Reference: 23.560r01v02

10 November 2023

Re: Paling Yards Wind Farm (SSD-29064077)
TRAFFIX Peer Review

Figure 5. Google Map of Route Survey A: Loads under 5.1 metres in height (Source: RJA & Google Maps, 2021)

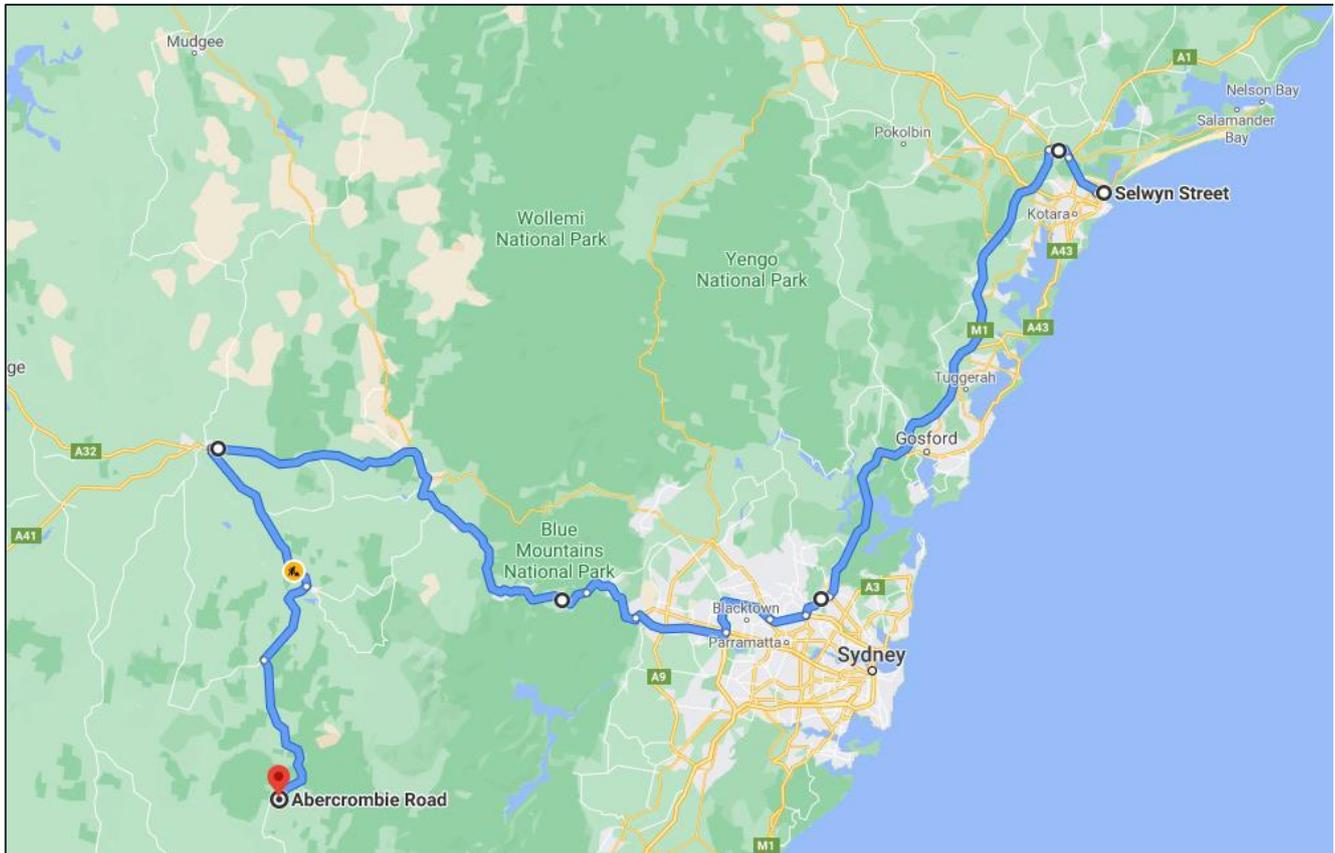
- RJA assessed two (2) transport route options recommending blades and loads up to 5.1 metres in loaded height are to use Route 1 and loads over 5.1 metres and up to 5.9 metres in height are to use route 2 – it is unclear as to why the TIA only adopted a single route when RJA's report suggests both routes are required.
